City of Albuquerque Stormwater Construction Site Inspection Report

Project Name:		Sunset Villa					
Location:		Sunset Gardens and Sunset Rd					
Site Contact Name & Agency	Phil L. - Sunset Villa			ESC File No.	K12E003		
	phillindborg@comcast.net			NPDES Id. No.	NMR12AX70		
Inspection Date:		06/24/20	Start/End Time:	1050/1100hrs			
CoA Stormwater Inspector:			Timothy E. Sims				
Construction Phase:		vertical					
Type of Inspection:	x	Regular	Storm Event	Post Storm Event >0.25"	311/Complaint	Follow Up

Erosion Sediment Control Plan

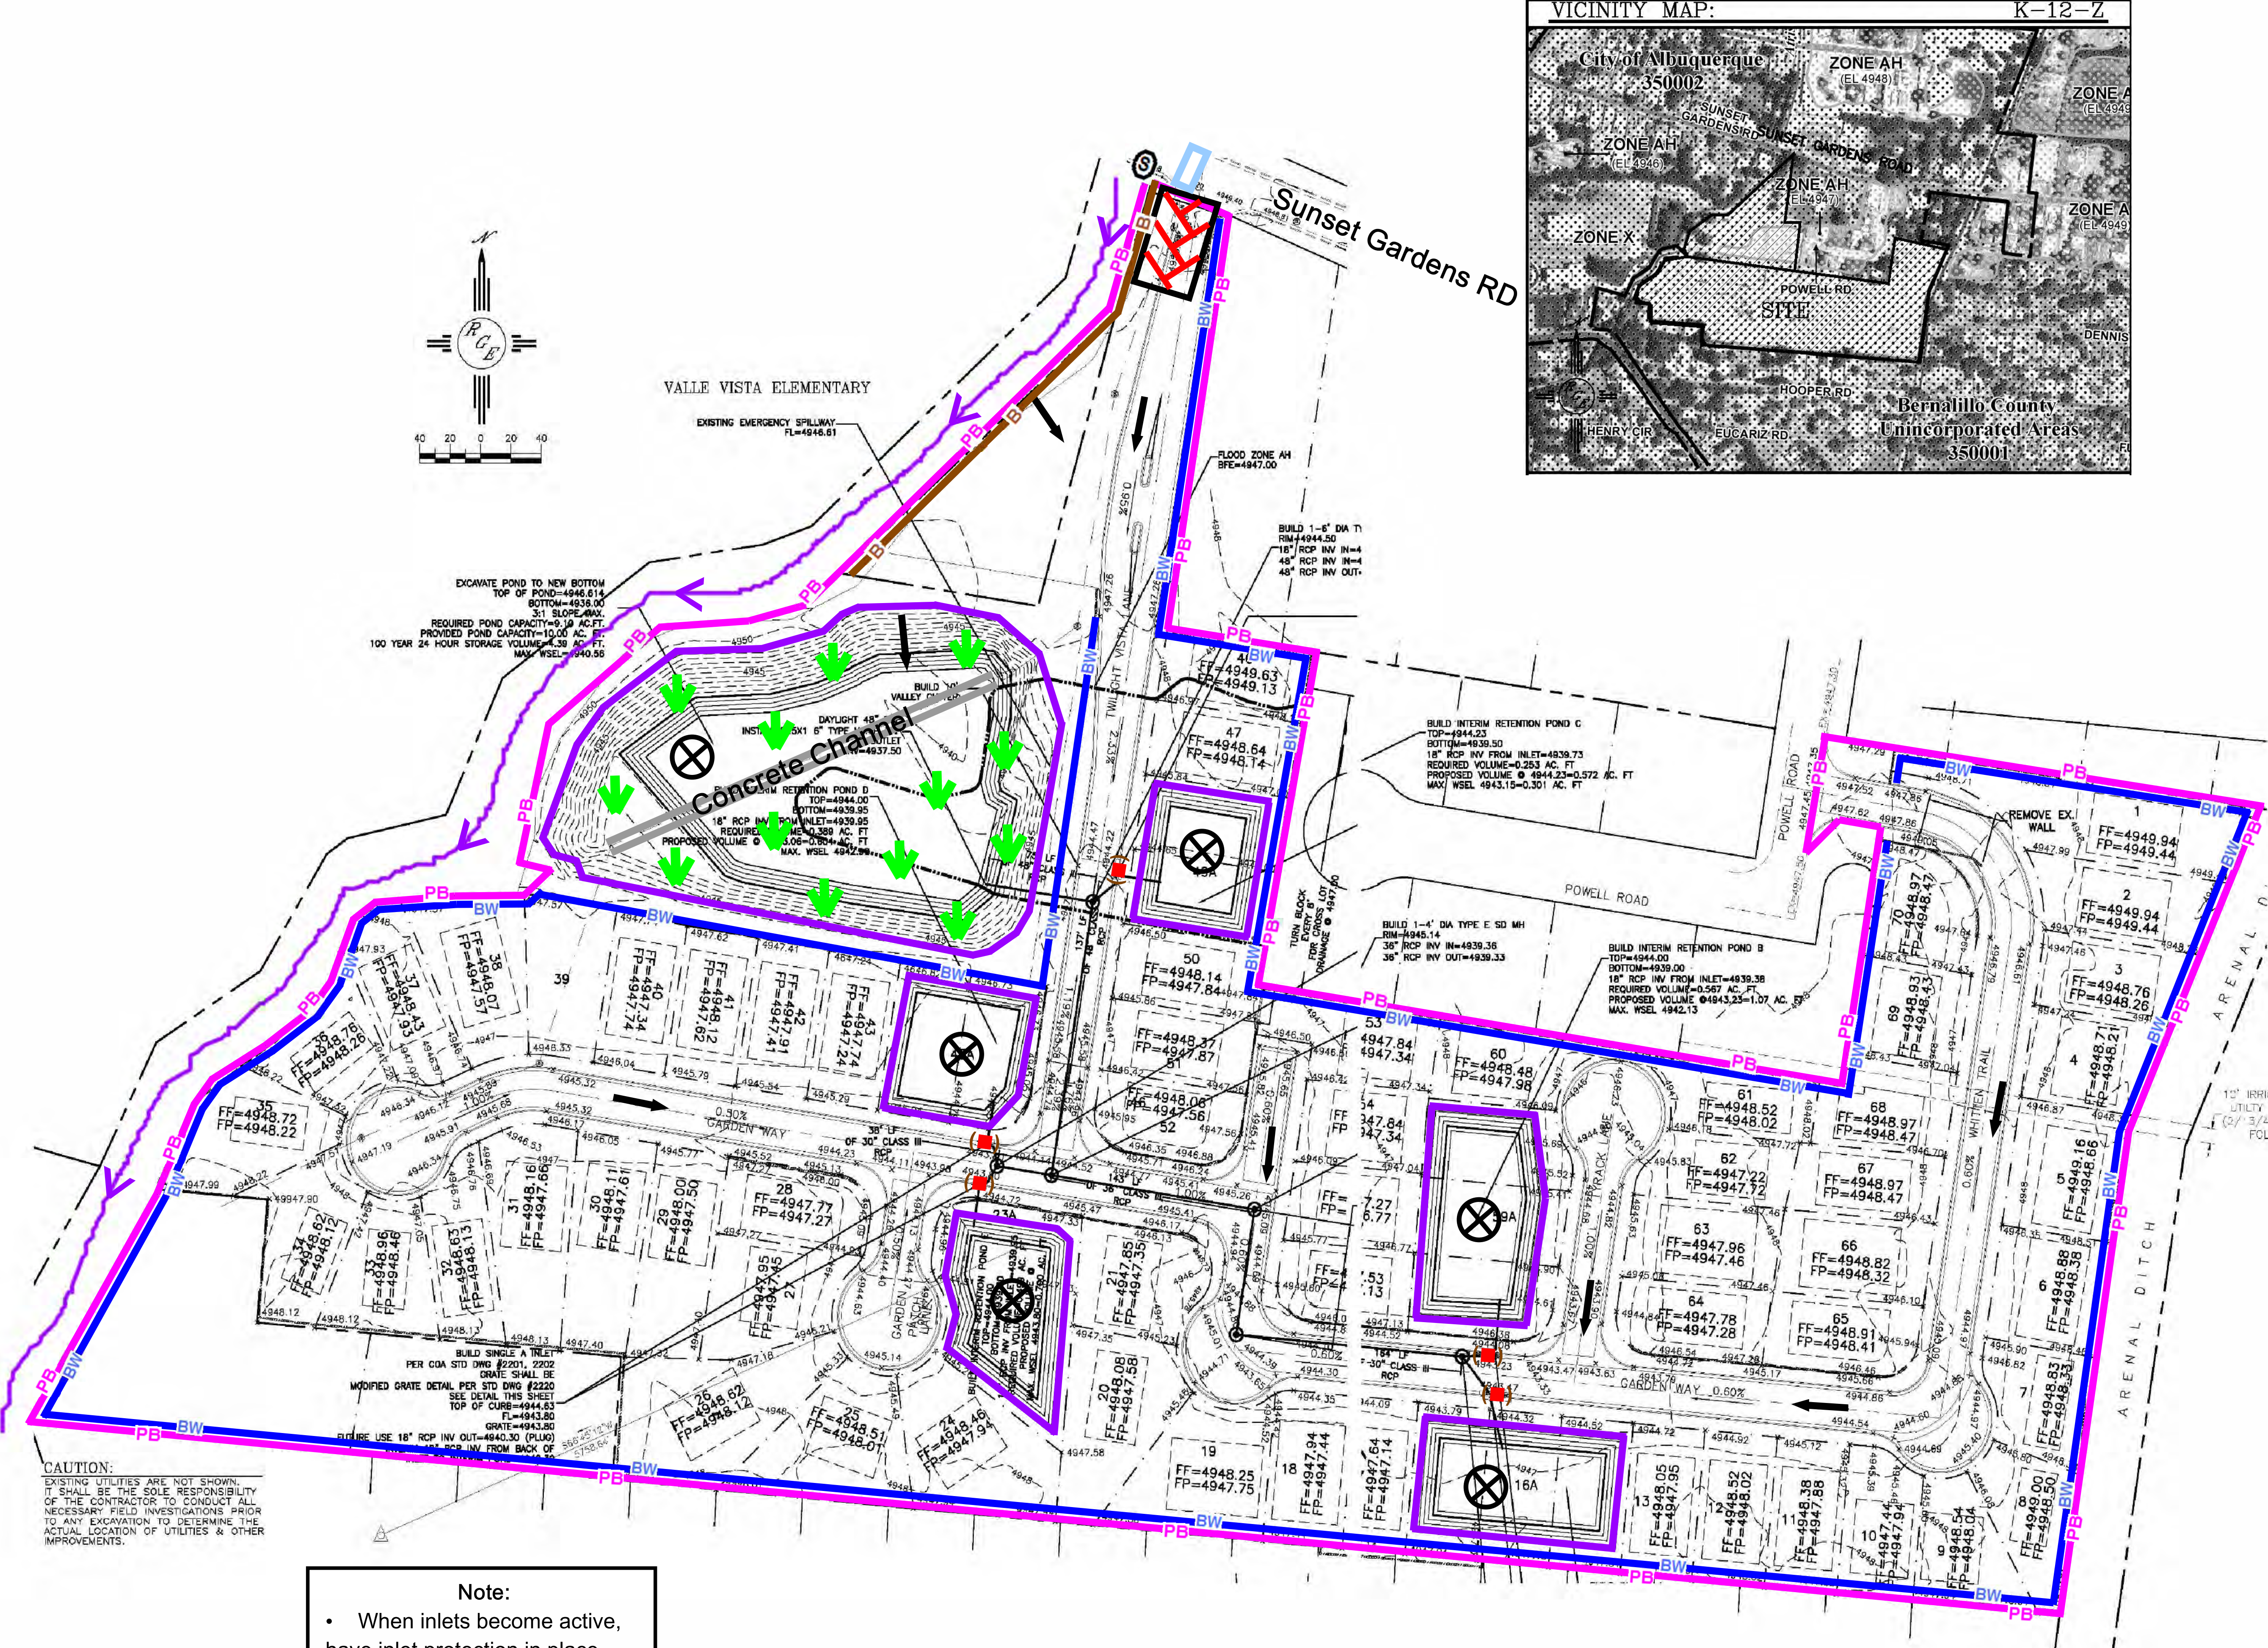
Item Number	Deficiency/ Corrective Action		
1	please provide inlet protection on all inlets		
2	Please provide latest SWPPP self-inspection report		
2.1	Discharge off site? (Y/N)	No	
4	Self Inspection Reports	requested	Latest report Date: 7/8/2019
